Engineers Comments Regarding Surface Water Drainage

Application Reference:	WA/60/26/PL	Reviewer Reference:	ADC/EXT2
Planning Officer:	Kathryn Welch	Date of Review:	18/08/2026
Site Name:	Land south of the Black Horse Pub Binsted Lane Binsted BN18 0LP		
Application Description:	Siting of 6 No. glamping pods with associated structures, access, car parking and landscaping (retrospective). This application may affect the setting of a listed building and is in CIL Zone 3 (Zero Rated) as other development.		
Assessment Number:	1

CLIENT	BINSTEAD FARMS LTD				
ARCHITECT	SIMON HARVEY DESIGNS LTD				
JOB TITLE	NESTLED, LAND ADJ BINSTEAD LANE BINSTEAD, ARUNDEL				
DRAWING TITLE	DRAINAGE DESIGN				
DRAWN	LH	ENGINEER	C SLADE	CHECKED	CS
DATE	JAN 2026		SCALE @ A1	1:200	
JOB No.	C3944	STATUS	DRAWING No.	101	REV.
		PL			3

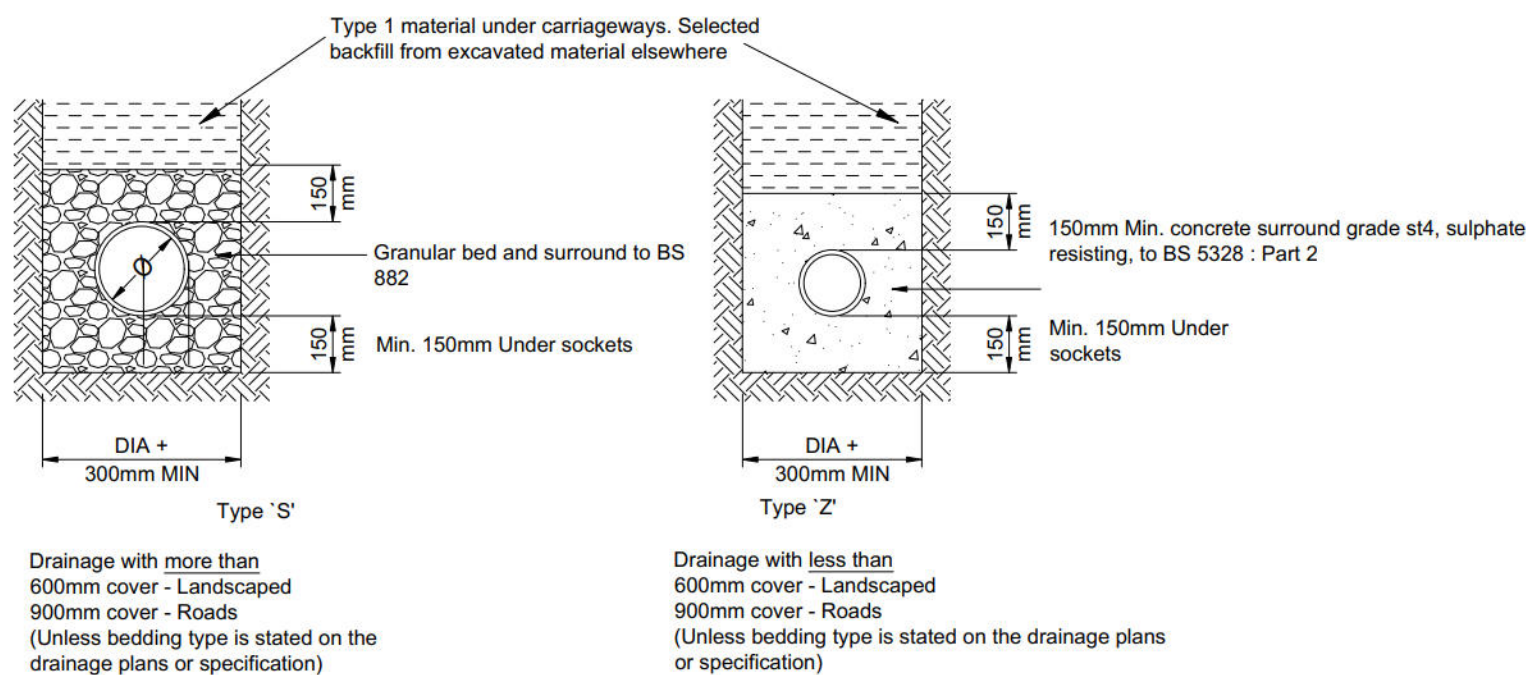
- 1.1. The discharge flow rate referenced in the submitted report is 1.9l/s but the calculations and drawings are based on 0.5l/s. Whilst 0.5l/s is marginally more than Qbar, it is acceptable.

TYPICAL DETENTION
BASIN CROSS SECTION

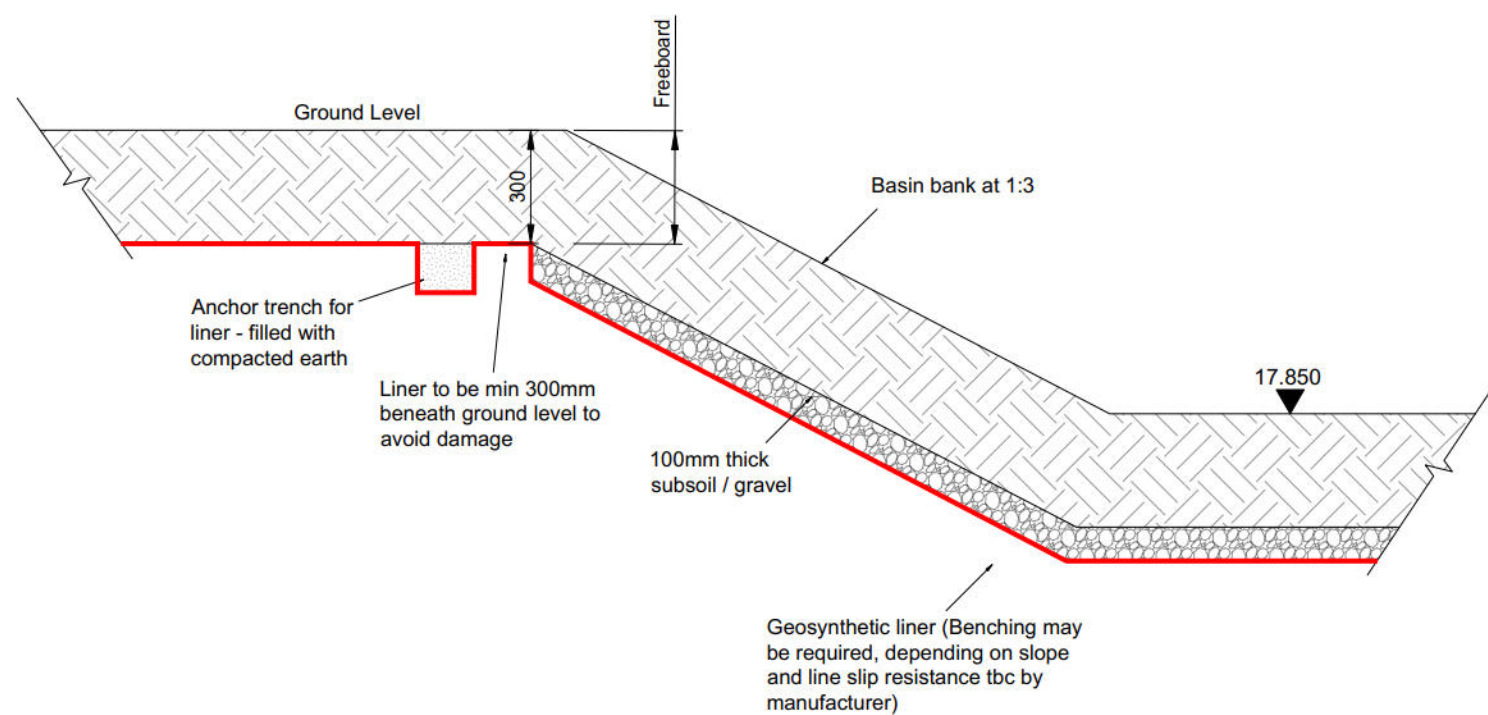
- 7.1. Buoyancy calculations have not been included for the basin liner but the recorded groundwater levels are not significantly above the base level, this can be dealt with as part of the DOC application.

1. Detailed drainage plans conforming to Local Planning Authority guidance,
2. Specifications for all surface water drainage components and associated infrastructure or flow control mechanisms,
3. Hydraulic modelling against a surcharged outfall.
4. Buoyancy calculations for the proposed basin.
5. Any relevant permissions relating to the discharge location, works to watercourses or adoption of the SuDS scheme. The scheme shall then be constructed as per the approved plans. The surface water drainage scheme shall remain for the lifetime of the development unless agreed in writing by the local planning authority. The local authority shall be granted access to inspect the sustainable drainage scheme for the lifetime of the development.
